Insert "PCD Number P264".

TRAFFIC IMPACT STUDY

Highway 24 Multifamily Rezone
El Paso County, Colorado

January 2026

Figure 2
EXISTING TRAFFIC
Volumes & Intersection Geometry
AM / PM Peak Traffic Hour
(ADT) : Average Daily Traffic

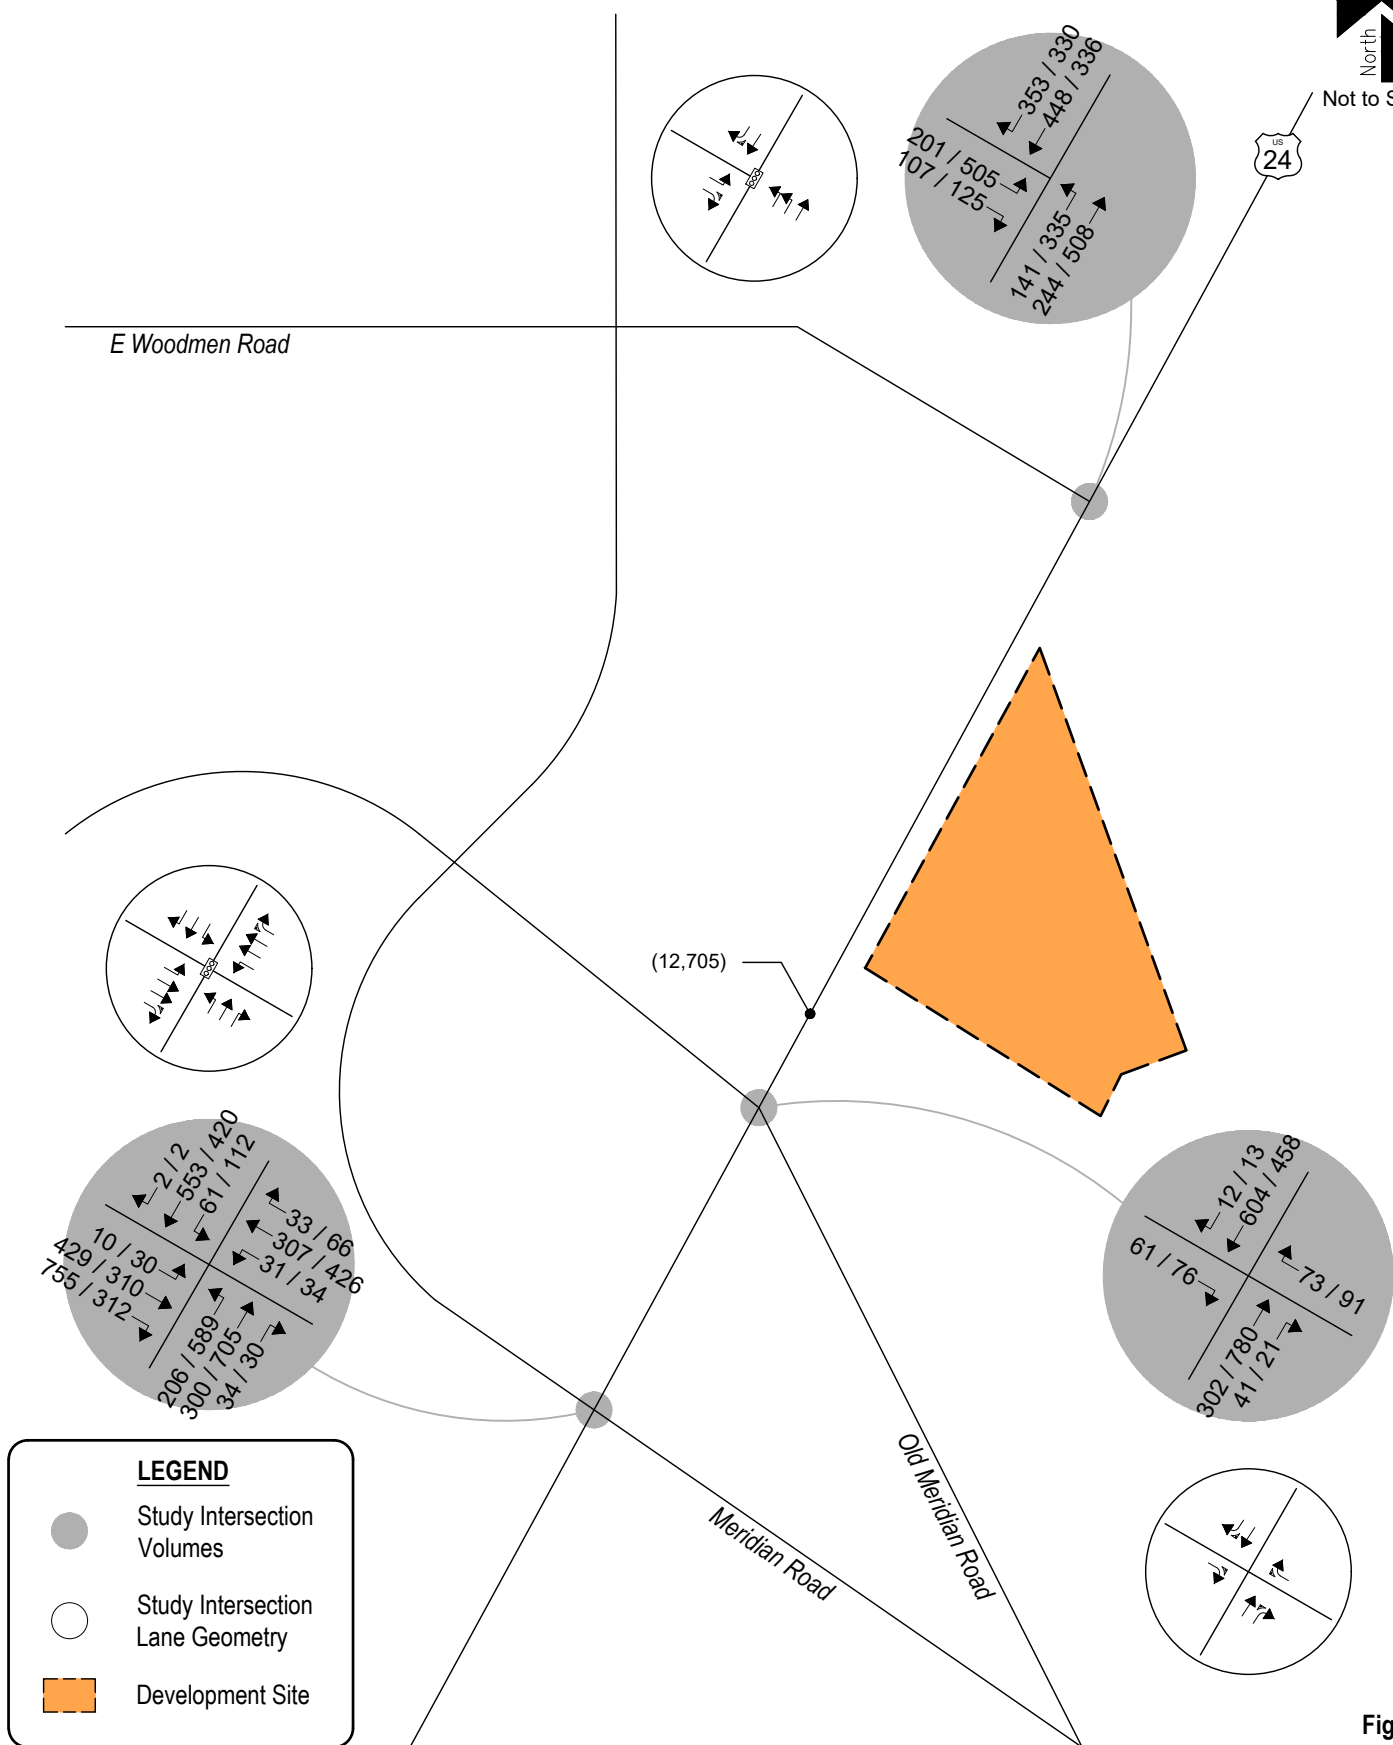
identify why Meridian and woodmen and Rolling Thunder/Meridian Road where not included in the study area. If thresholds per criteria are not met, then please state that.

The Meridian Road intersections with Rolling Thunder Way and Woodmen Road were not included as this development is not expected to affect these intersections by 10 percent or greater. Discussion added to the report.

Figure 3
BACKGROUND TRAFFIC - YEAR 2028
Volumes & Intersection Geometry
AM / PM Peak Traffic Hour
(ADT) : Average Daily Traffic

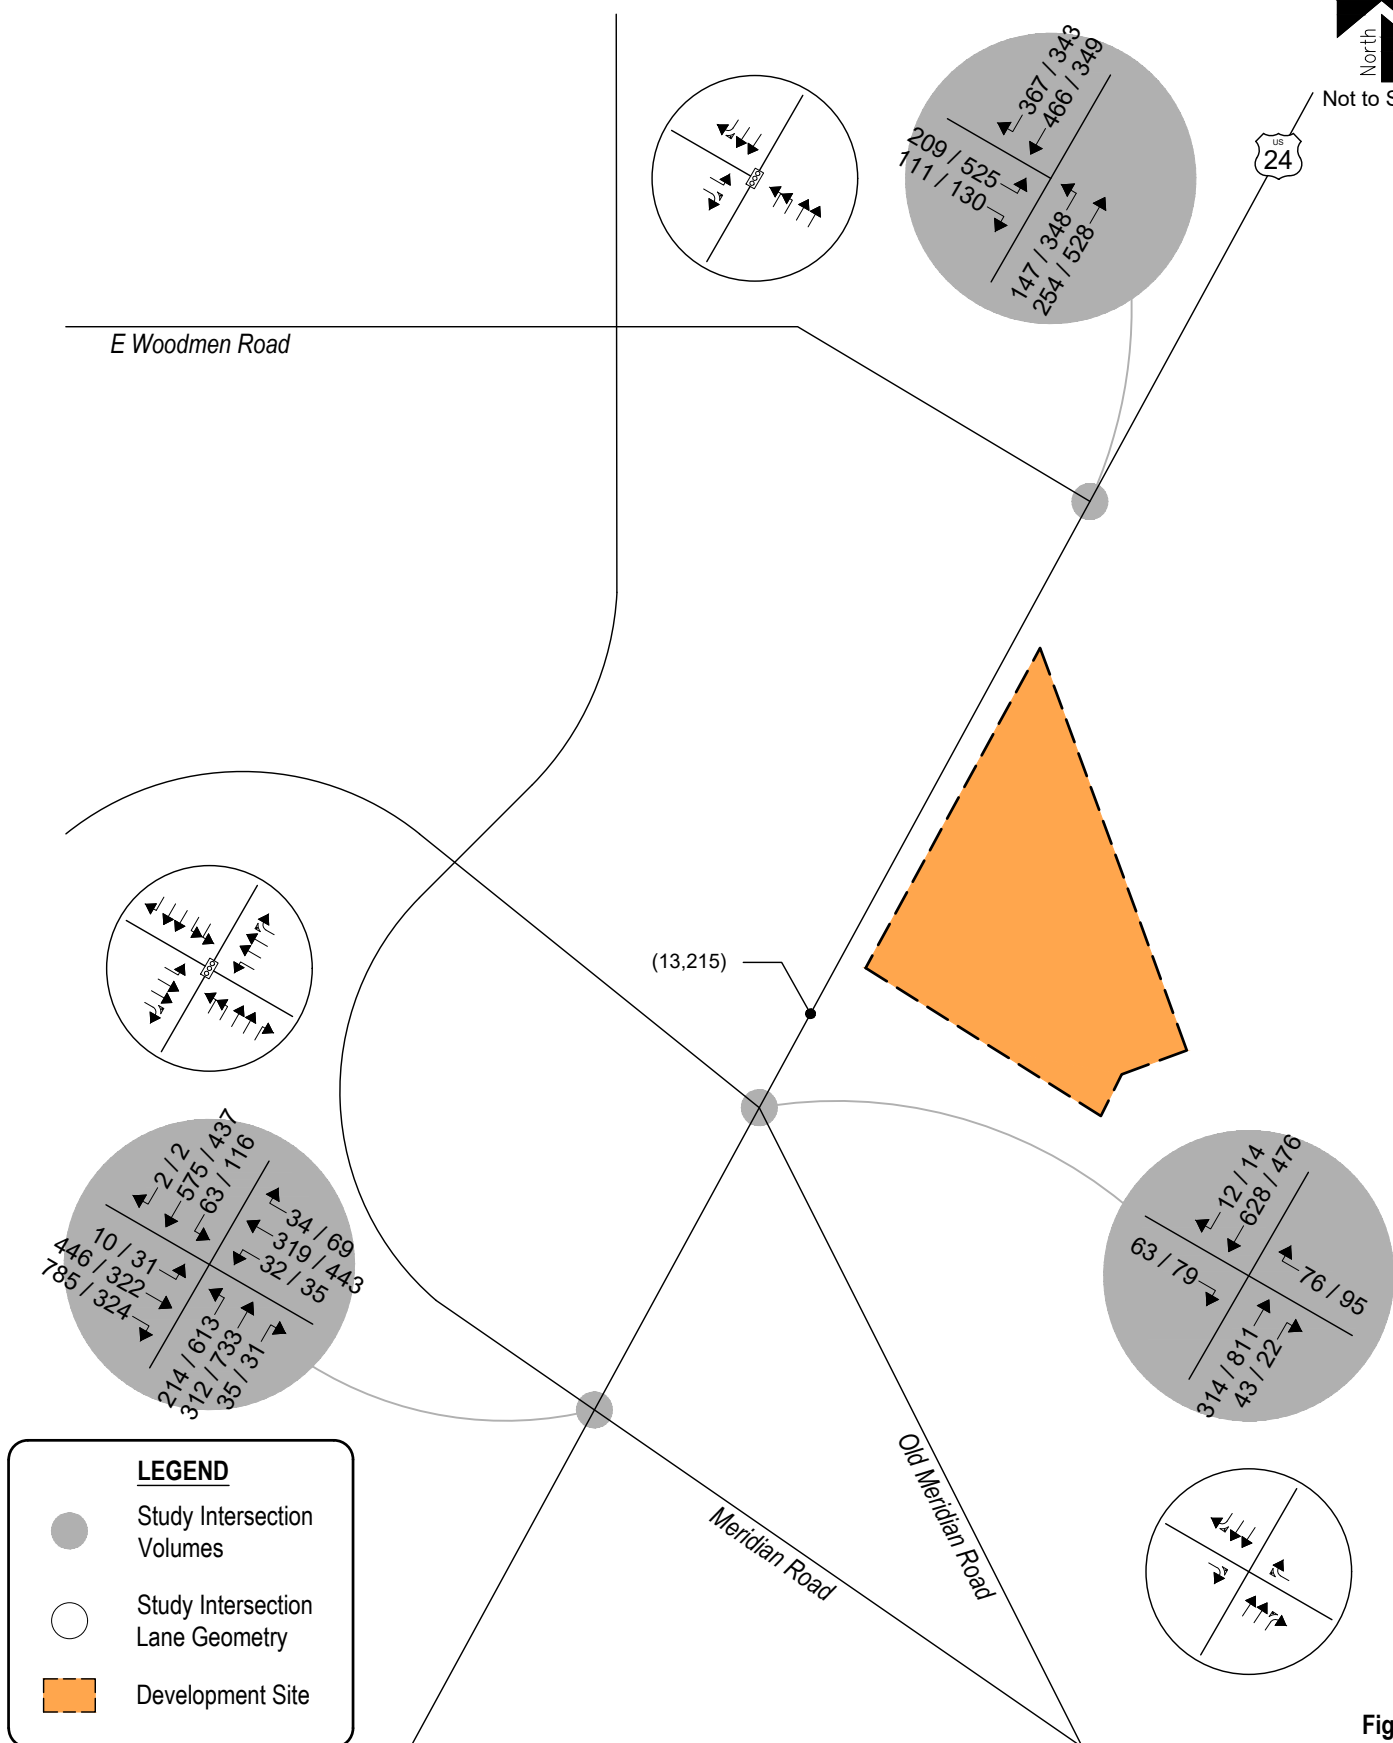
This appears low in comparison to other traffic studies in the area. Please be sure to account for other developments in the area specifically Falcon Field development at Woodmen/Hwy 24 (PCD File No. SP232, SF2435). Update the analysis as necessary.

this will be a 4 leg intersection with the falcon field project. Revise accordingly

Falcon Field development added, please know that due to EDARP limitations it is difficult to find every study within a certain development area. If further traffic studies are requested to be considered, please provide where necessary.

Study updated to match the Falcon Fields traffic study.
